Planning Applications 3/2022/1143 and 1144: Proposed external and internal alterations including the replacement of a conservatory with a new extension. Resubmission of 3/2022/0839.

Application for Listed Building Consent for proposed external and internal alterations including the replacement of a conservatory with a new extension. Resubmission of 3/2022/0889.

Waddington Hall, Clitheroe Road, Waddington BB7 3HP

Drawing Title  
Proposed Secondary Glazing Details

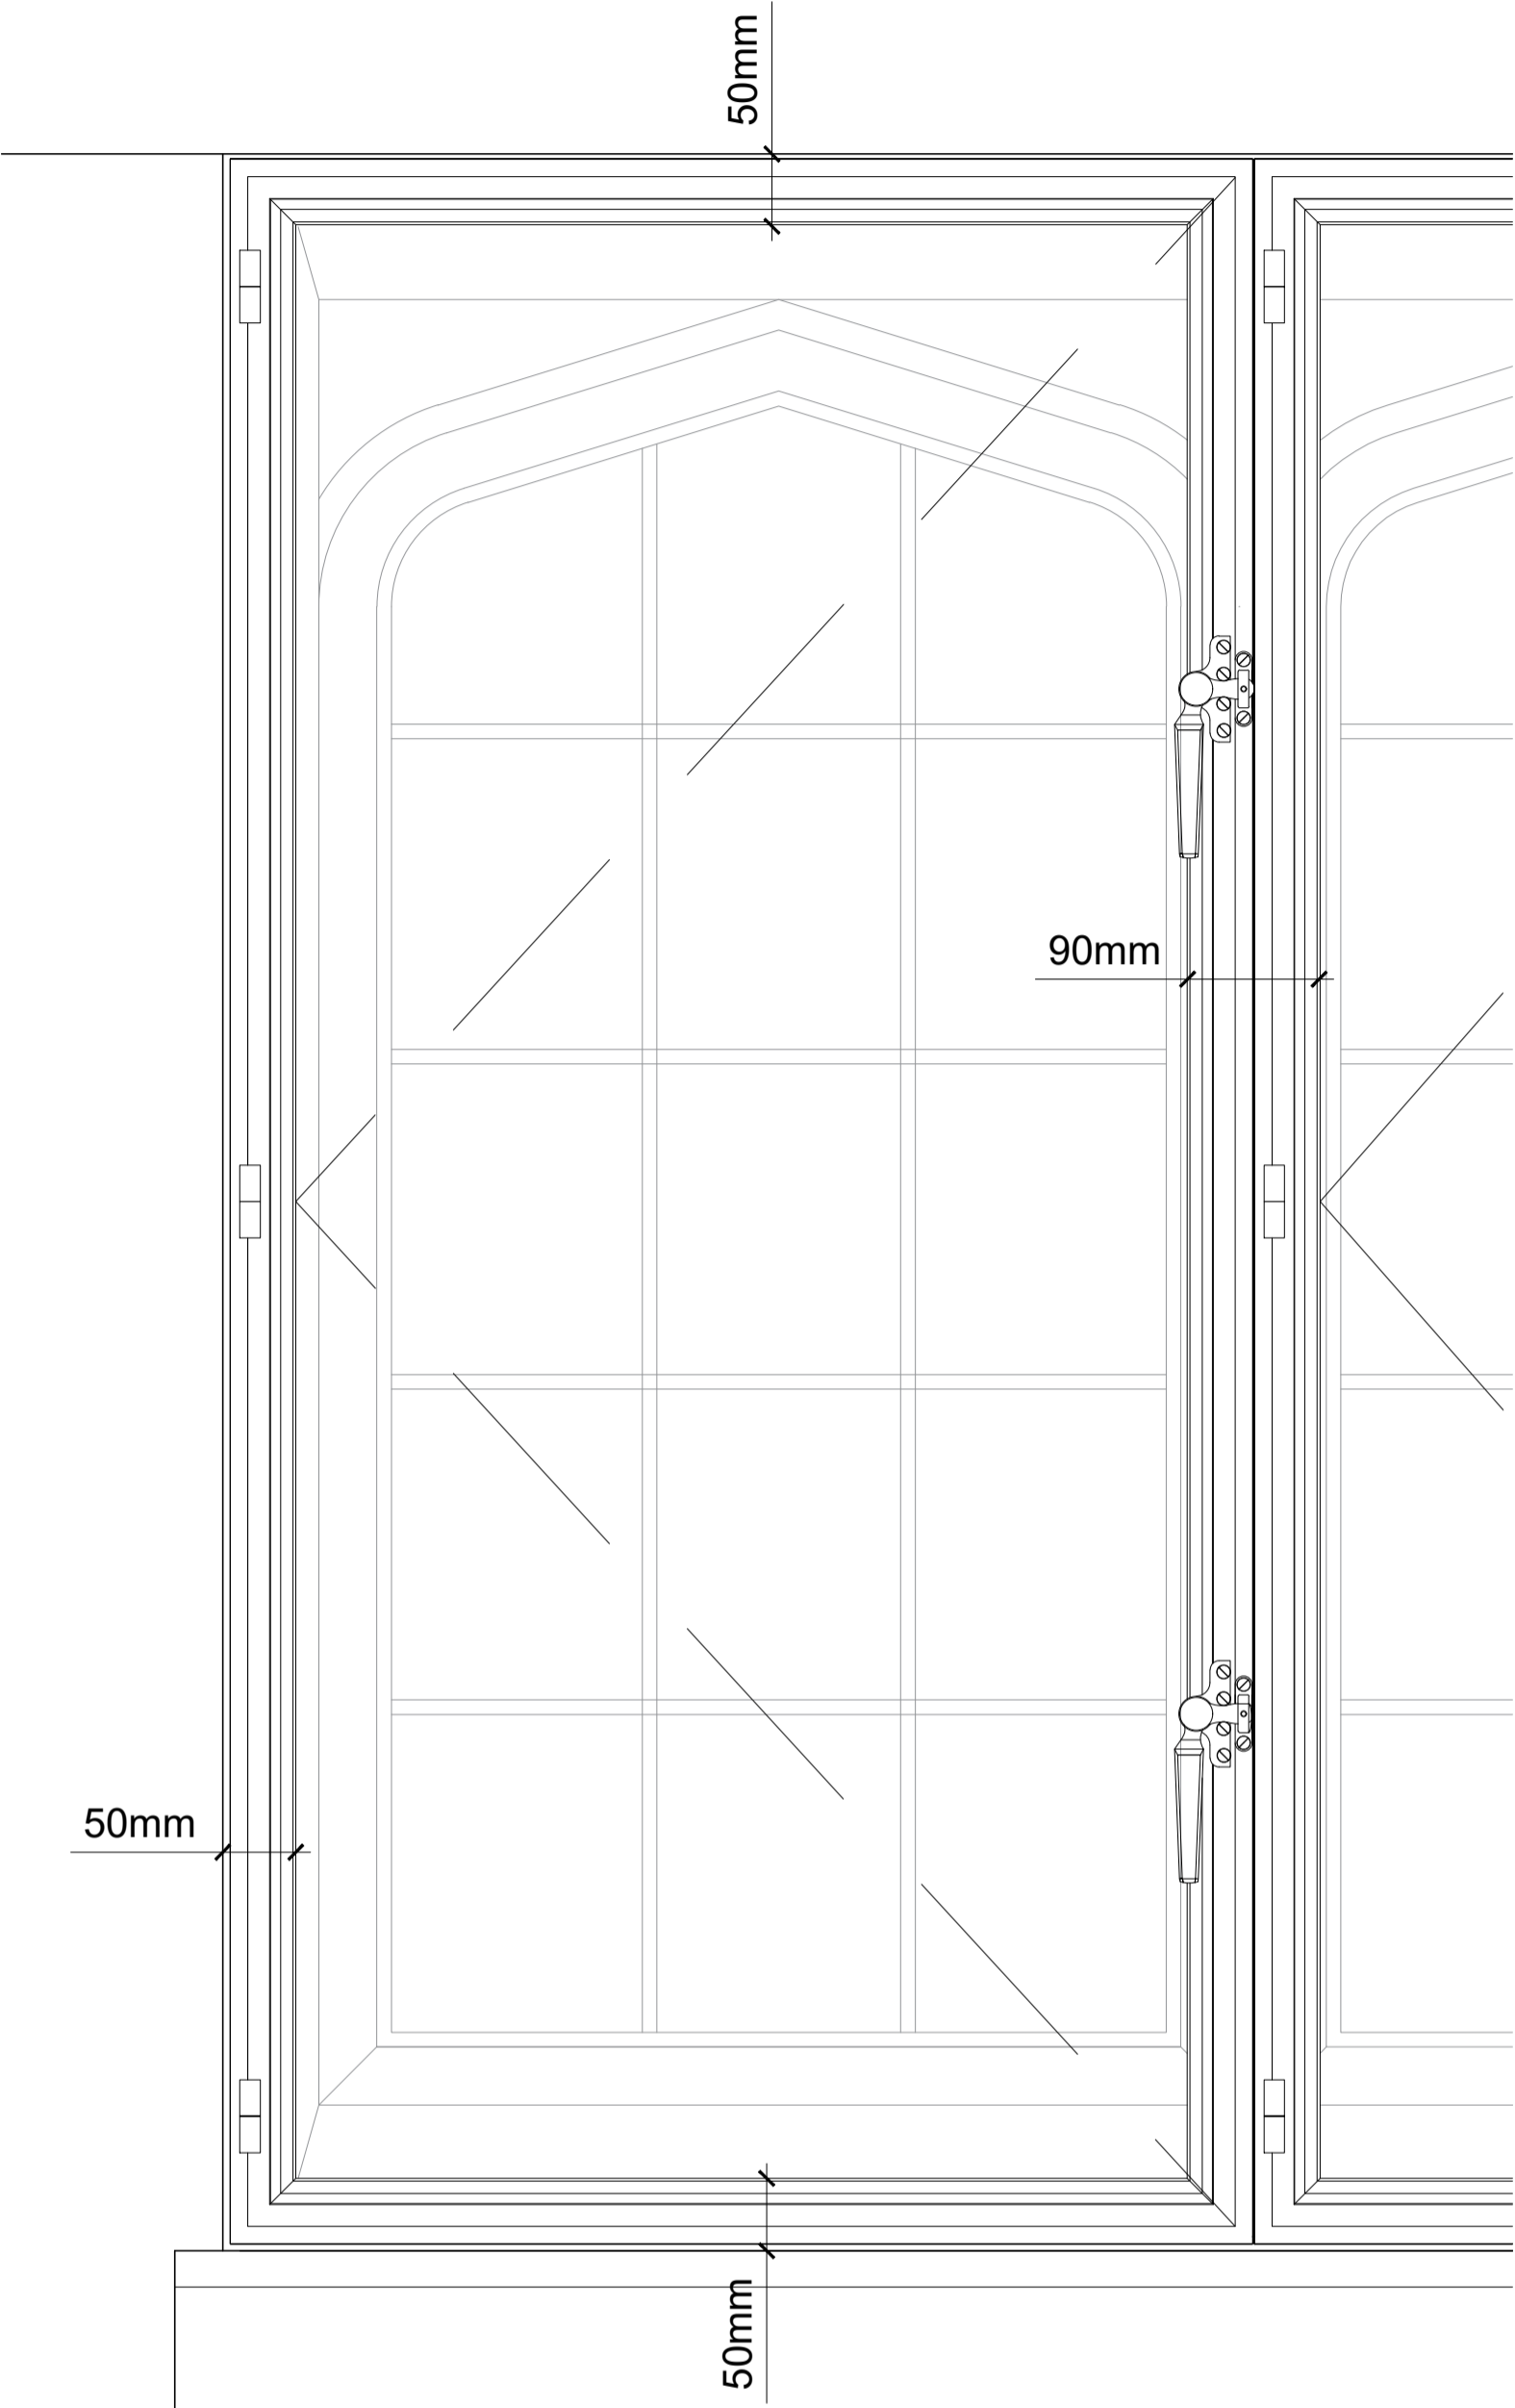
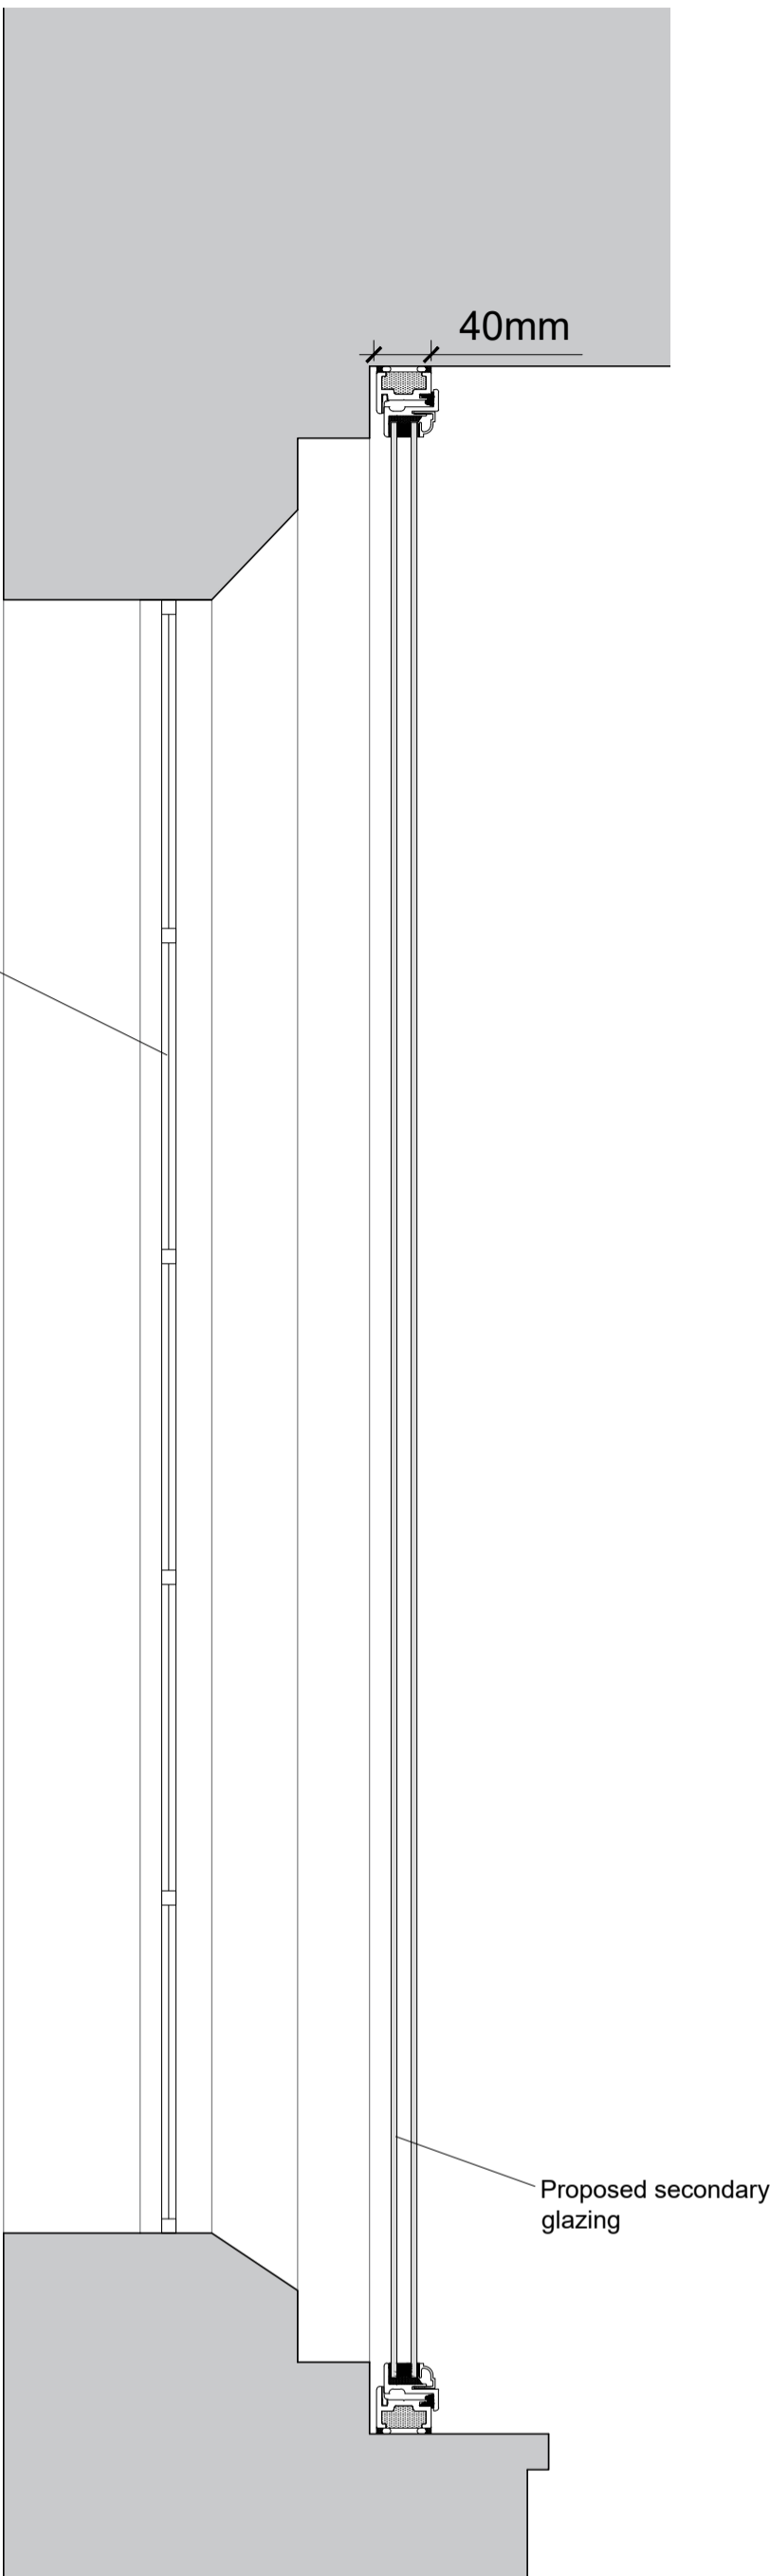
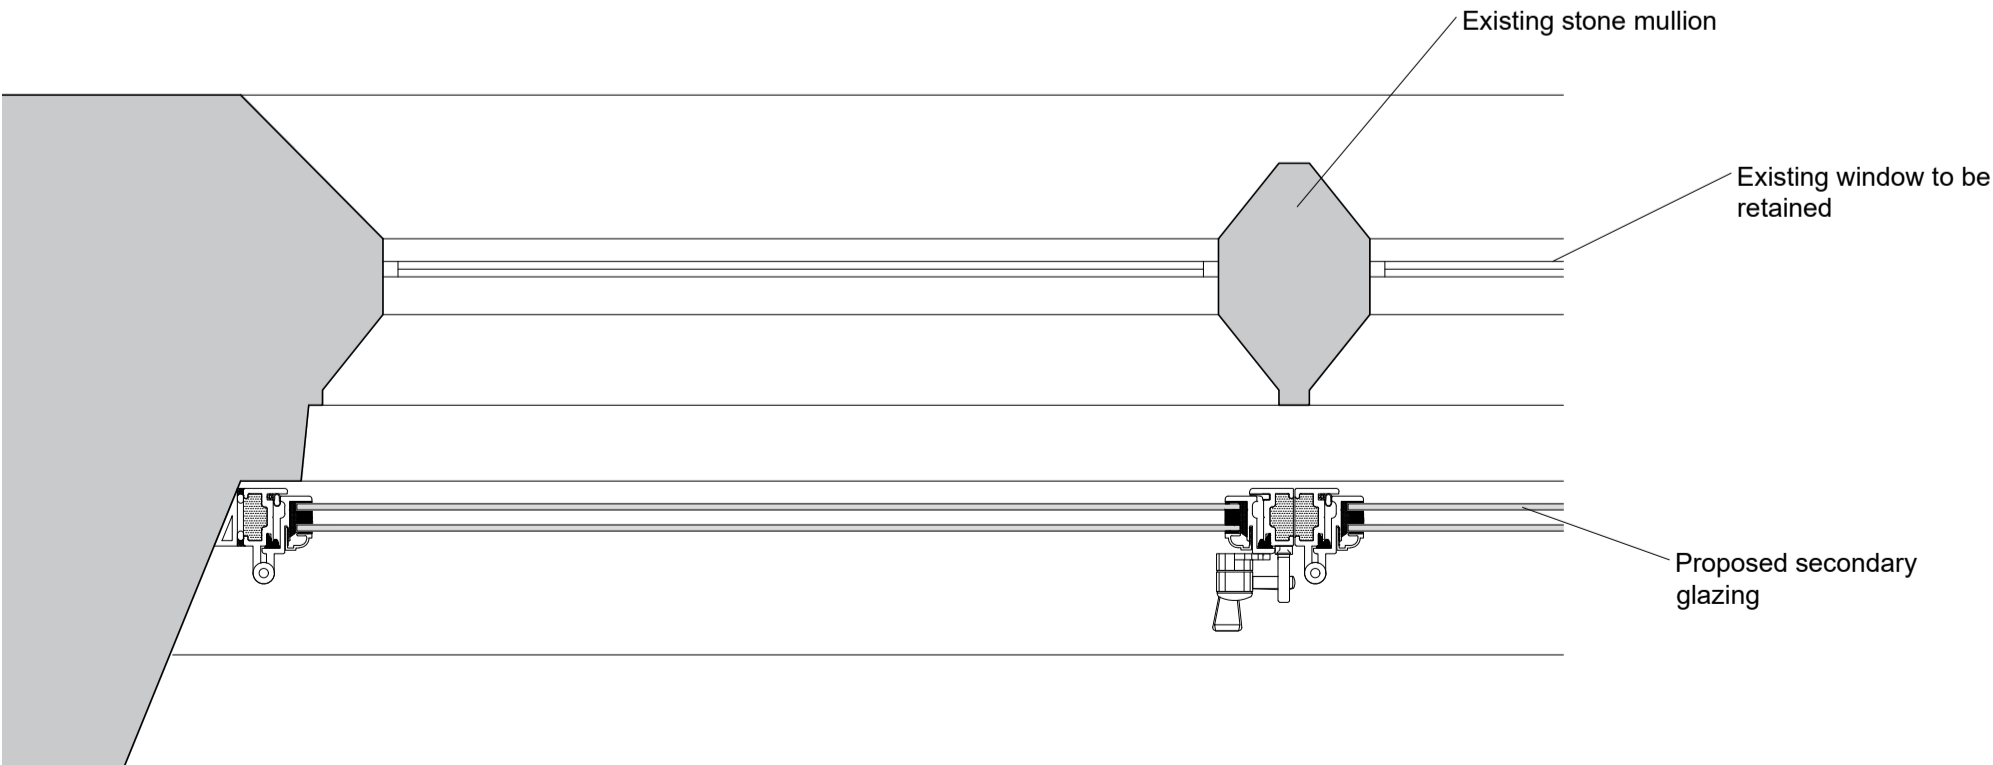
Where the proposed secondary glazing panels will be placed across pre-1900 windows, it is recommended that the frames are not let into any dressed stonework and that as far as possible all fixings are made with non-corrosive materials (e.g. stainless steel) set into existing joints. The detailed design of the glazing units should seek to avoid causing any deterioration of the internal faces of historic stonework due to, for example, significant changes to temperatures or moisture levels in the gap between the extant windows and new units. These details should be agreed with the Conservation Officer.
